CITY OF ALBUQUERQUE

May 8, 2018

RE: **Global Storage- Coors**
3421 Coors Blvd NW
Grading and Drainage Plan
Engineer's Stamp Date 4/30/18
Hydrology File: G11D071

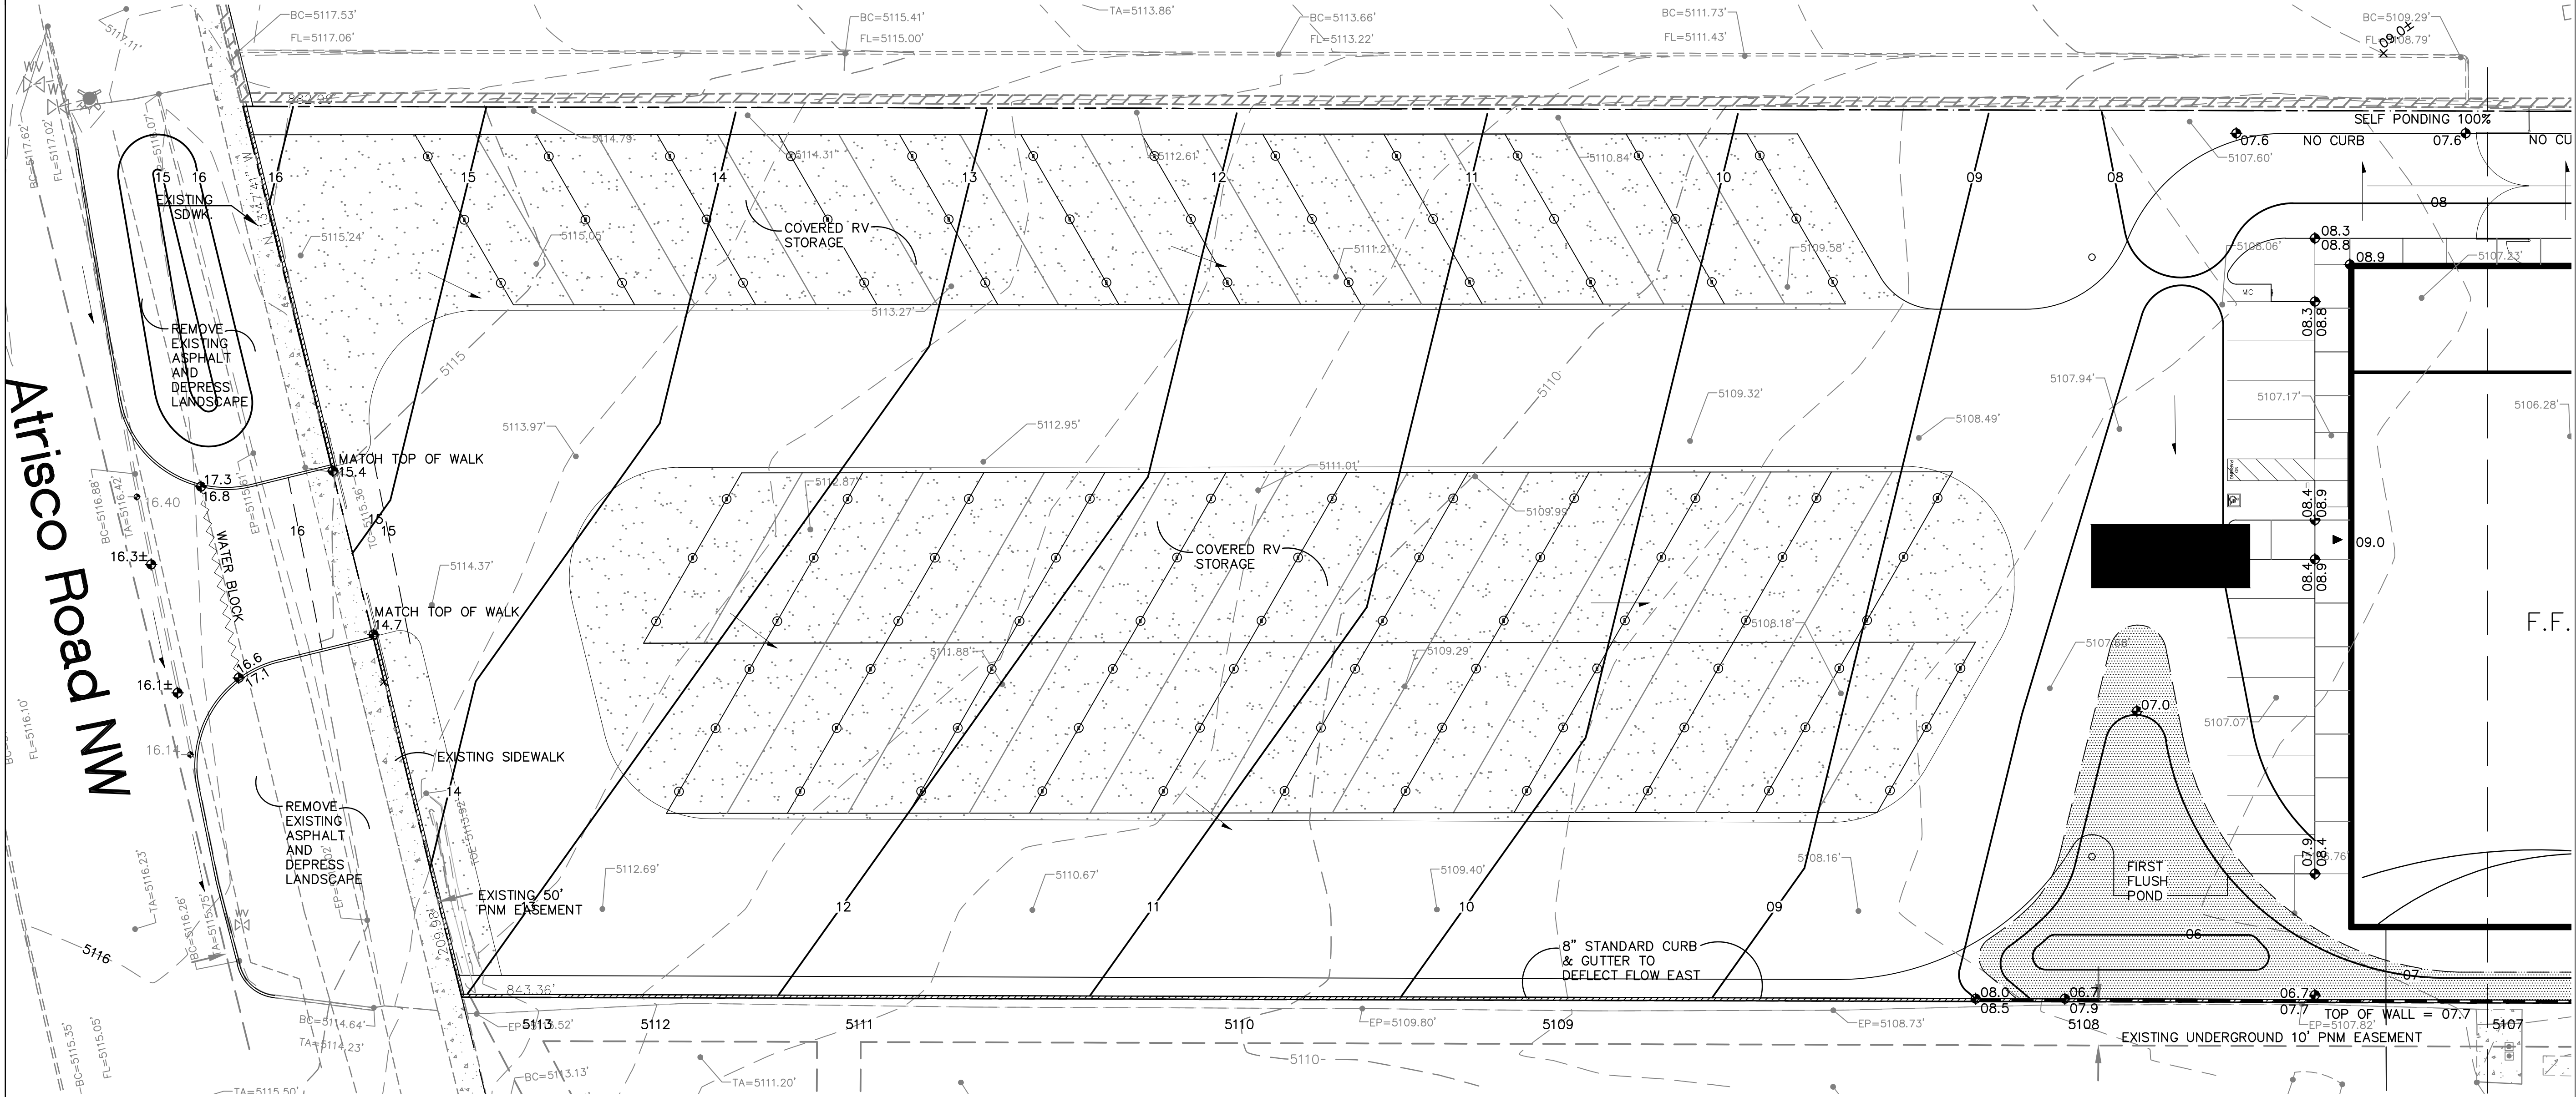
4. Along Atrisco, size the retention areas to be able to pond the portions of Atrisco that drain to them. Since this will all occur within the ROW, a work order, or excavation permit at minimum, will be needed. Also include a 0.87' water block at this drive entrance unless calculations can be provided to support a smaller water block.
5. There appear to be a few areas around the dumpster access where impervious areas are not being retained on-site. Please add detail to show how these areas are being captured. If unable to capture and retain on-site, quantify the first flush bypass volume and state on plans. Payment of fee in-lieu will then be required at building permit.

CG-102

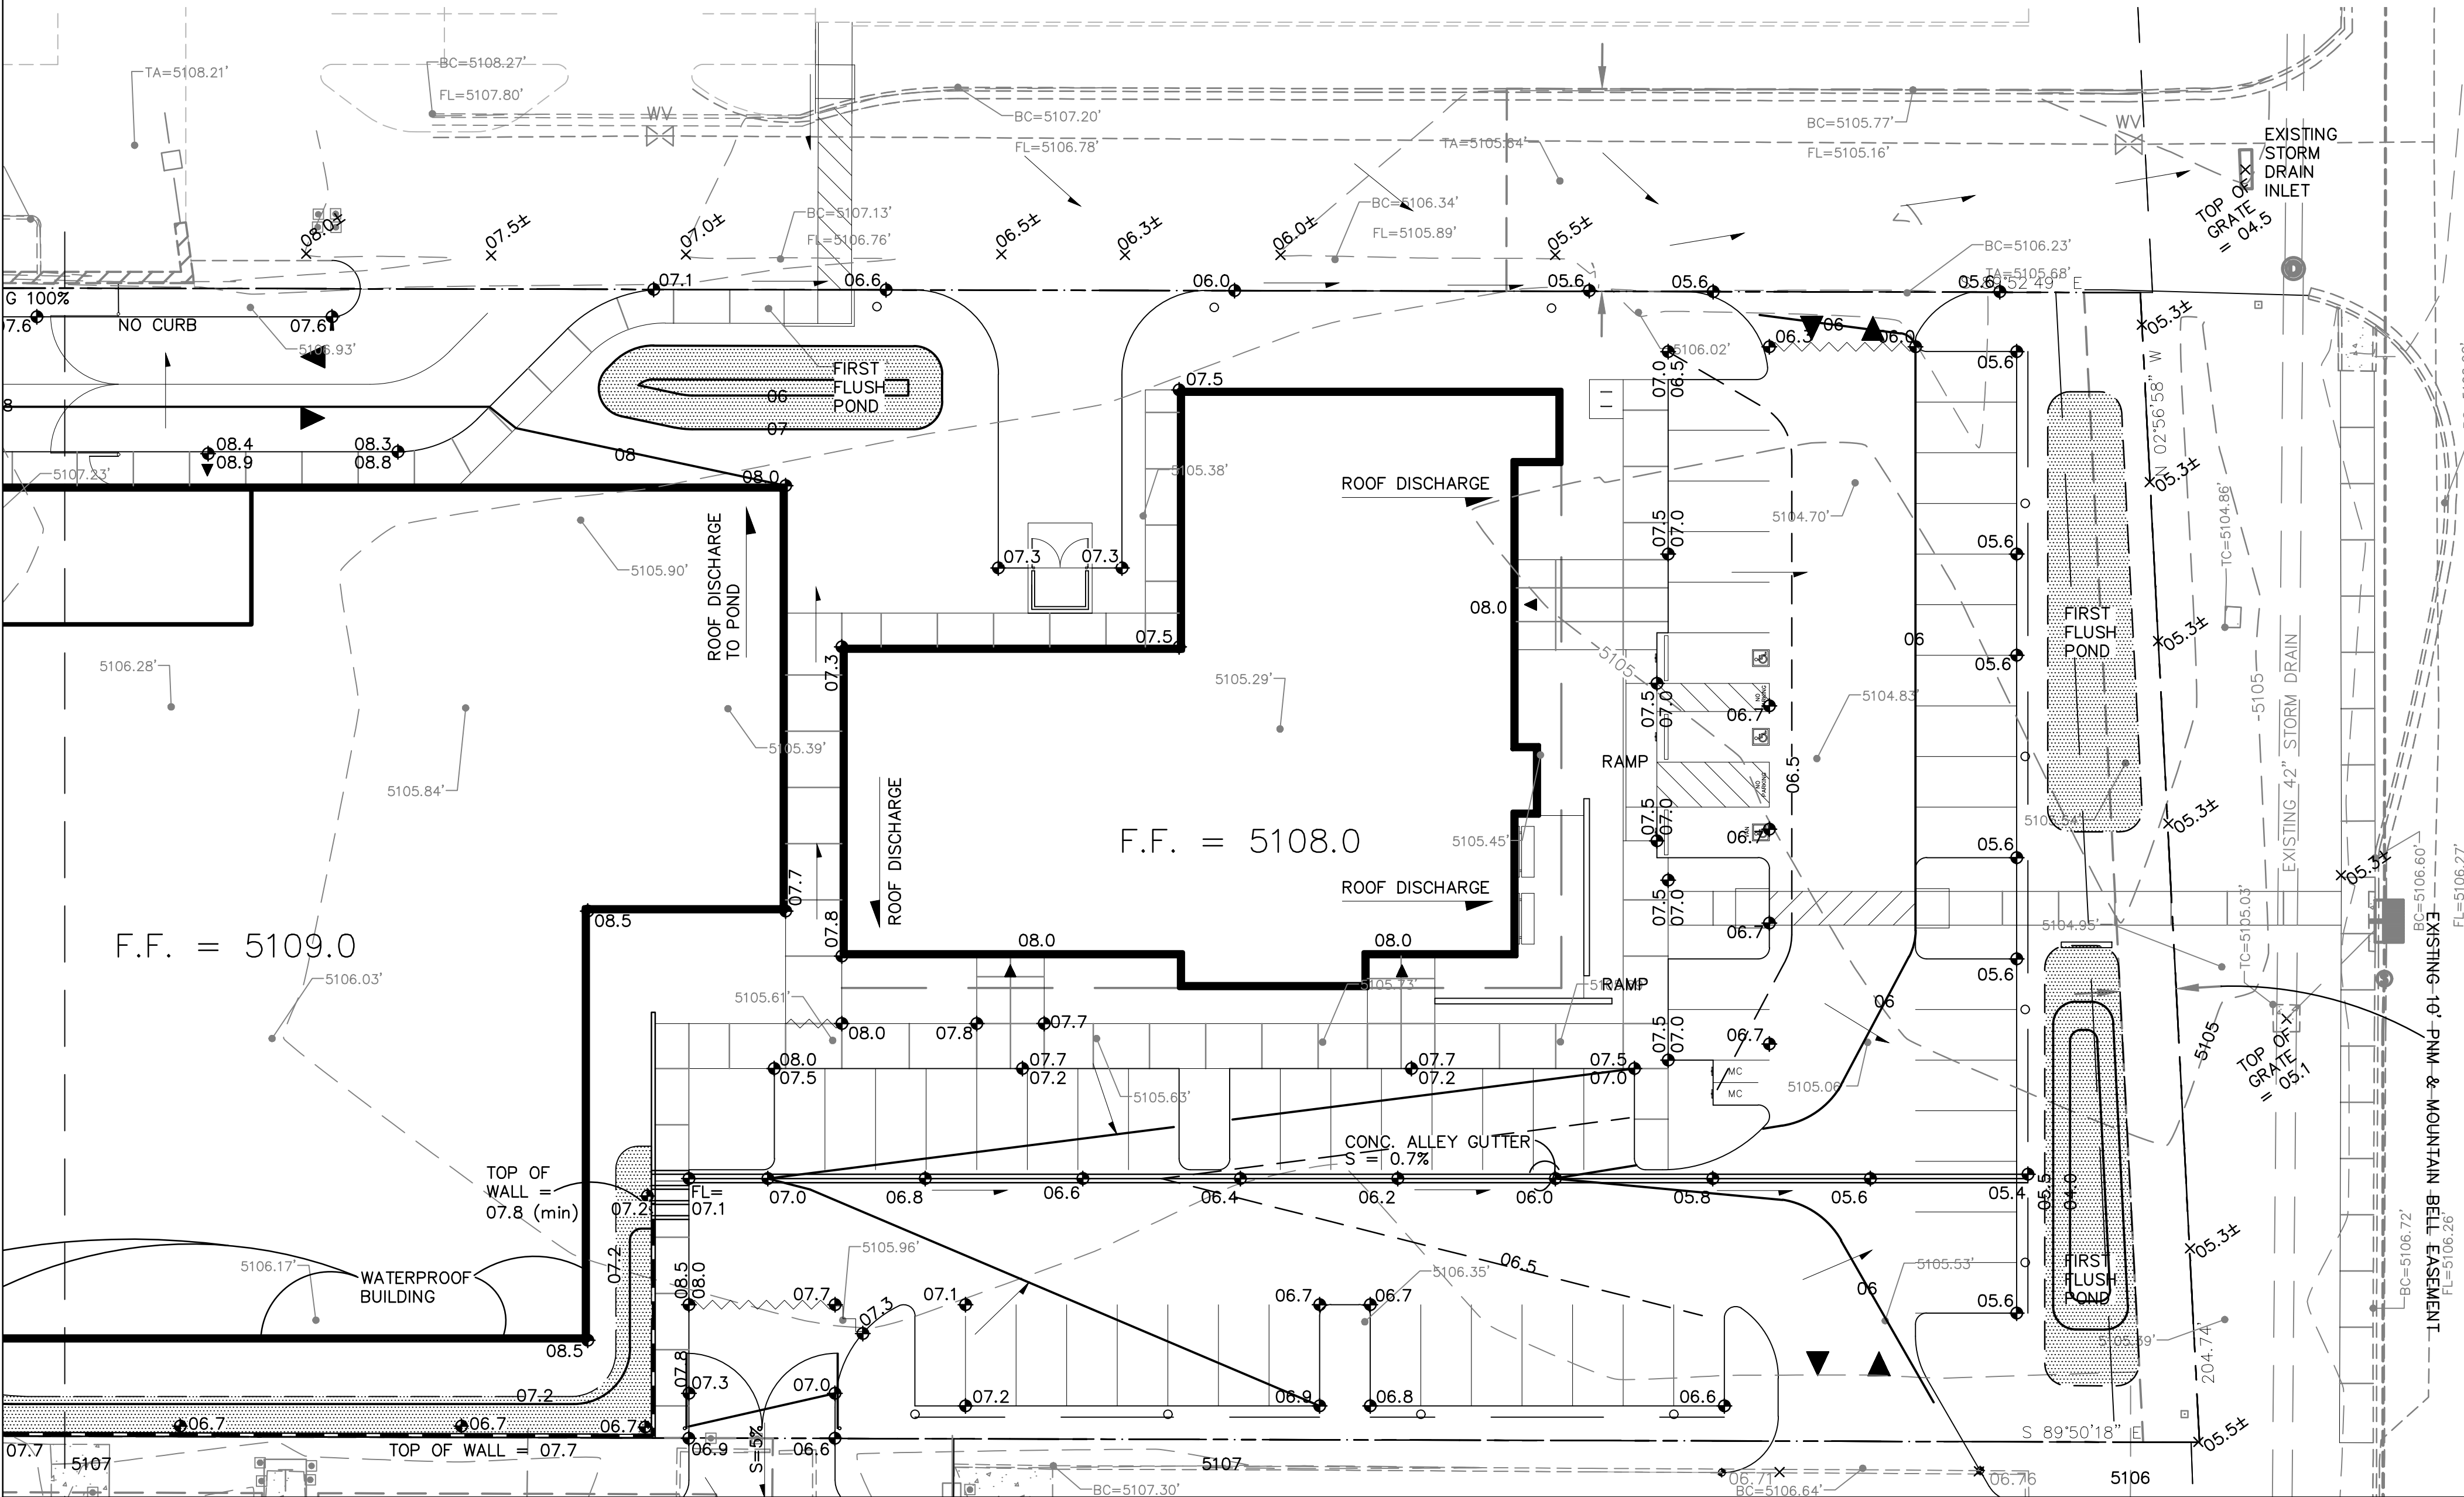
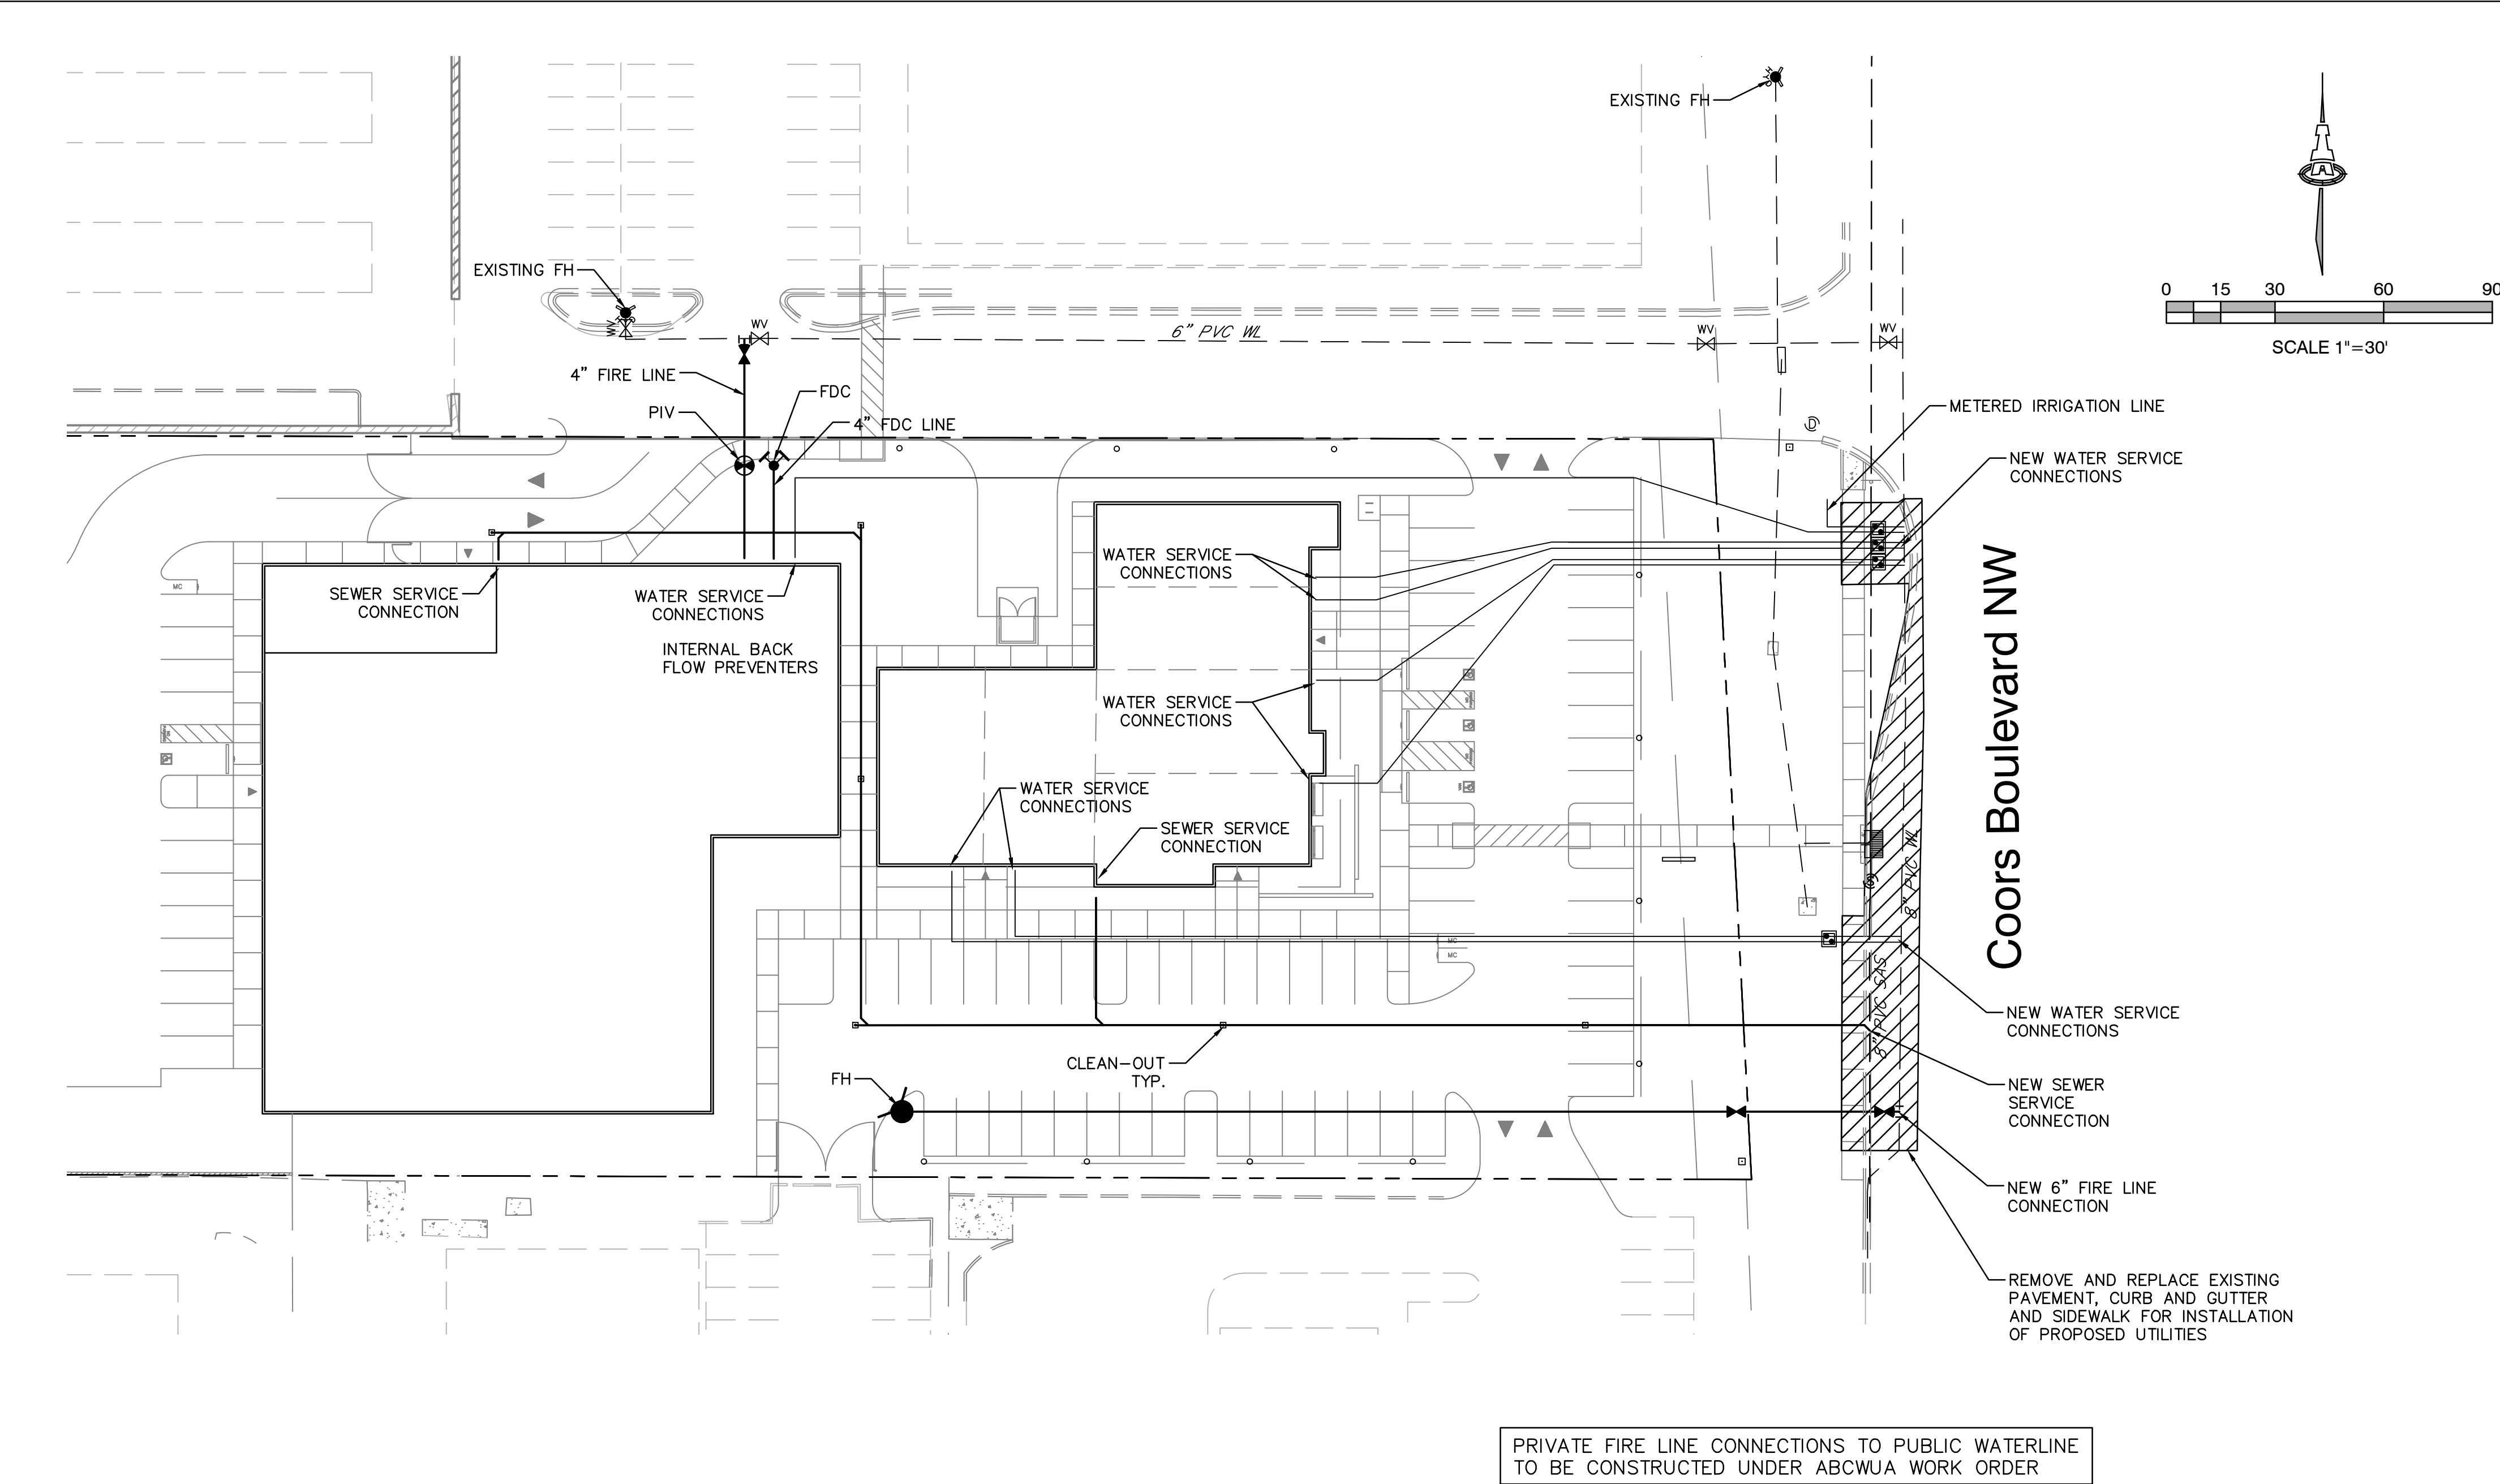
1. Correct the land treatment type for the historic flows; land treatment B is more appropriate for an undeveloped site.
2. Please clarify areas of impervious vs. pervious surfacing. The covered RV storage areas in Basin 1 need to be assessed as impervious area for your developed conditions flow.
3. The detention ponds along Coors need to be sized and shown on this plan, as well and their outfalls (orifice plates). Additional details can be shown on the building permit plan.
